From: Sue Howell [REDACTED]
Sent: 27 November 2024 16:09
To: Planning.Responses <Planning.Responses@arun.gov.uk>
Cc: Jessica Riches <Jessica.Riches@arun.gov.uk>
Subject: Planning Consultation on: F/14/24/RES, F15/24/RES, F/16/24/RES

From: Arun District Council Leisure & Greenspace

Application ref: F/14/24/RES, F/15/24/RES, F/16/24/RES

Location: Land at Ford Airfield Ford

Neighbourhood Park LAP
RM4

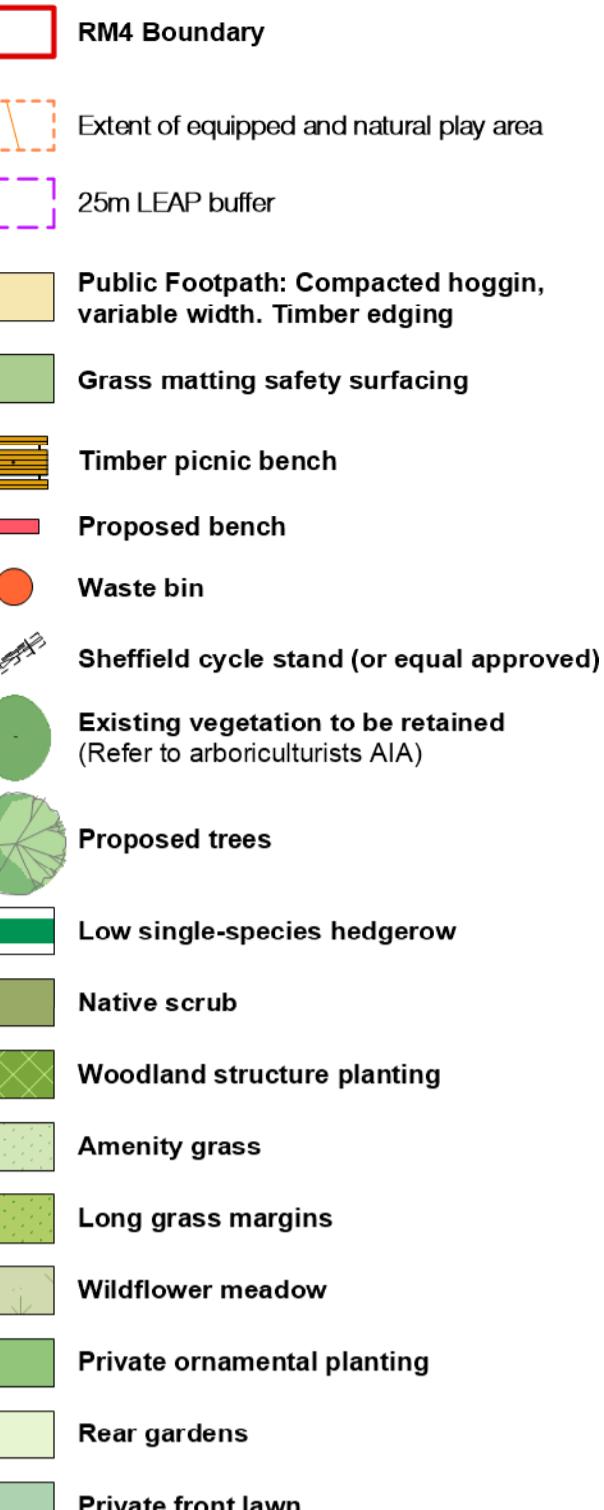
This reserved matters includes a Neighbourhood Pocket Park, a LEAP and several LAPs. The LEAP and LAPs are all of a sufficient size that accord with the play strategy in the approved Design Code, and all have appropriate buffer distances to ensure adequate amenity of occupiers.

The play areas have been created with the approved Design Code themes in mind and there is a number of high quality bespoke items. Nonetheless, there are couple of items which the council would want to amend to maximise the playspace and ensure that items are not duplicated. However, it is not proposed to approve these as part of the reserved matters application. Therefore, the Case officer should ensure that these areas are conditioned for approval at a later stage, and that all
